Re: Independent Expert Scientific Committee on Coal Seam Gas and Large Coal Mining Development
advice on Cobbora Coal Project (EPBC 2011/6158)

Ref 2162570C-DMS-WAT-008 RevC

Subject Cobbora Coal Project - Surface Water Assessment - Responses to comments from the Independent Expert Scientific Committee

Figure 3.1 Conceptual hydrogeological cross-sections for Talbragar River, Sandy Creek and Laheys Creek

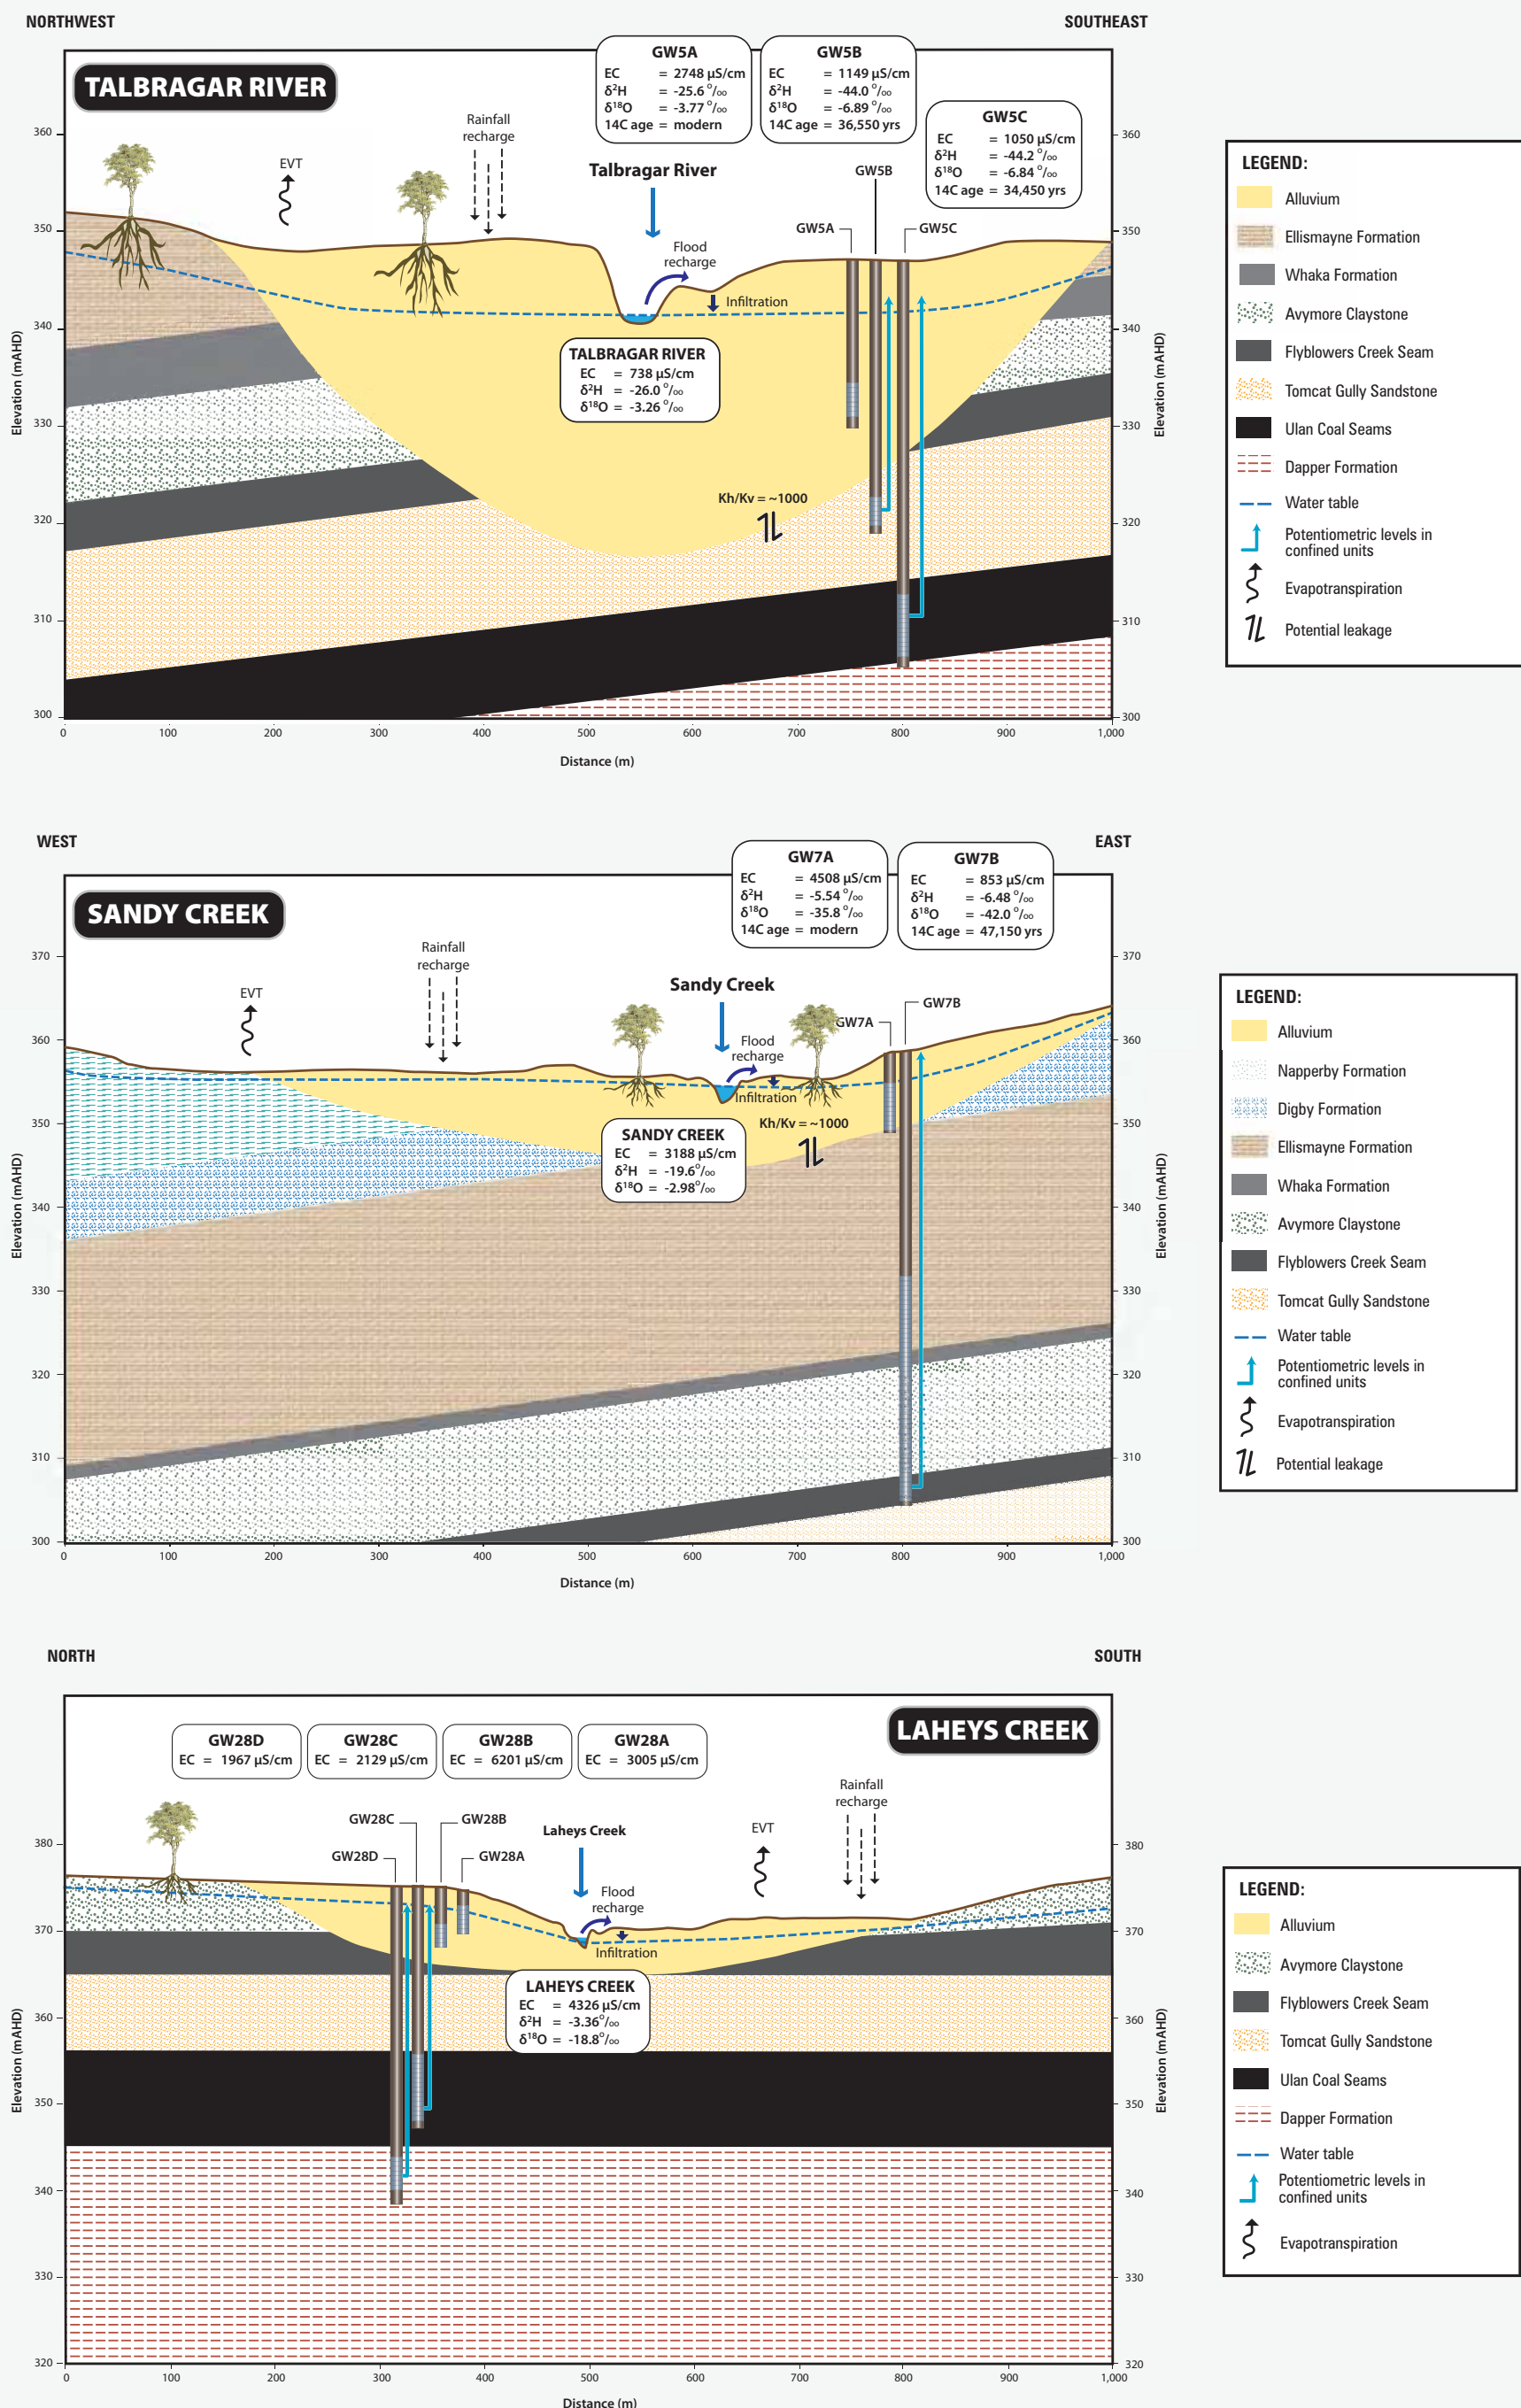
- b. The Jurassic Purlawaugh Beds are a major source of salt in the Sandy Creek sub-catchment and the Talbragar River catchment. The Jurassic Purlawaugh Beds and the Pilliga Sandstone, should be included in the geological conceptual model and then translated into the numerical groundwater model; and

The Jurassic Purlawaugh Formation and Pilliga Sandstone were considered in the Groundwater Assessment, and were included as a distinct layer in the groundwater model. It was found that groundwater flow from the Jurassic beds was insignificant compared with the Triassic strata. Regional groundwater quality monitoring (Figure 5.12 of the Groundwater Assessment) does not support a high source of salinity from the Purlawaugh Formation. Sampling indicates that groundwater within and immediately down-gradient of the Purlawaugh Formation is of a similar or lower salinity (e.g. bore GW18; 2306 $\mu\text{S}/\text{cm}$) to samples collected from the Triassic rocks in recharge areas such as the ridges within the Project area (e.g. bore GW24; 2970 $\mu\text{S}/\text{cm}$). This implies that the risk of adverse salinity impact from enhanced recharge via the Purlawaugh Formation is negligible.

Figure 5.3A Maximum predicted drawdown in water table aquifer

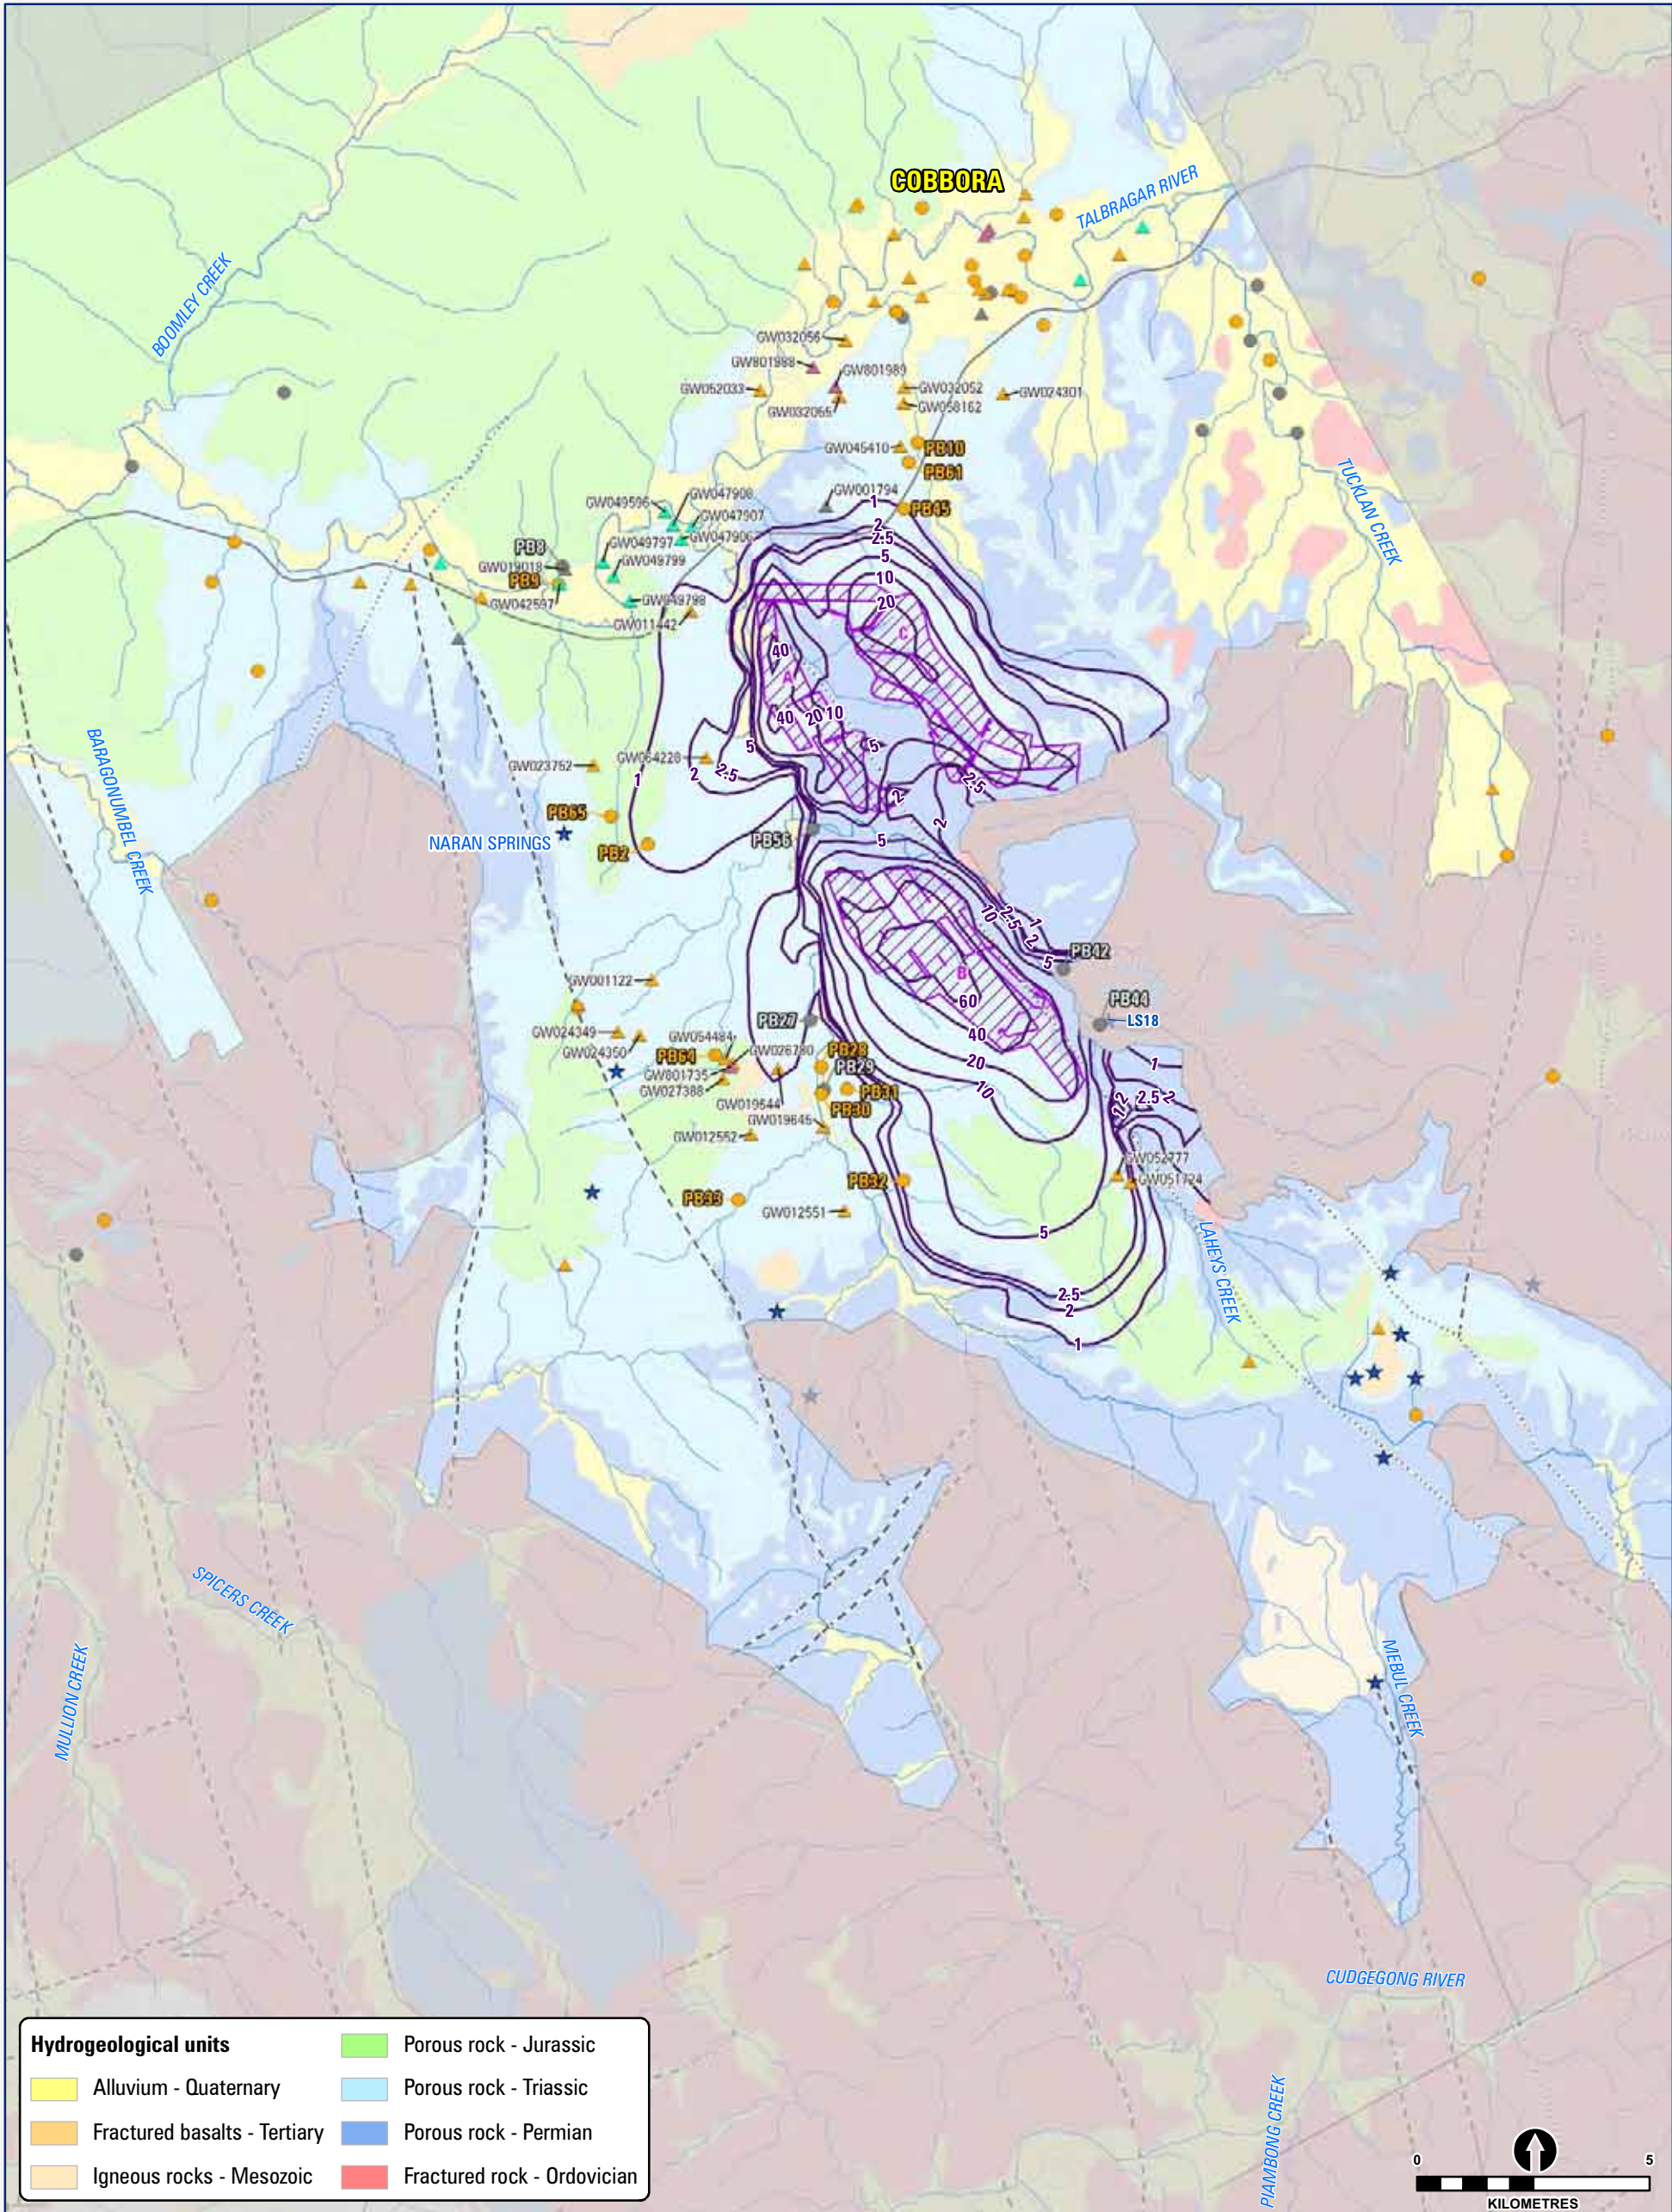
- b. The regional 1 m drawdown is predicted to extend 5 km to the south, 4 km to the west and 3 km to the north and east of the mining area highlighting the need to determine the potential regional impacts on water; and

The groundwater model adequately shows the potential water table drawdown extents in relation to groundwater users and surface water sources. The impacts on vegetation and irrigation areas located away

from the major creek lines will be negligible because the depth to groundwater increases from <3 m near the creeks to >15 m beneath the interfluvies and ridges.
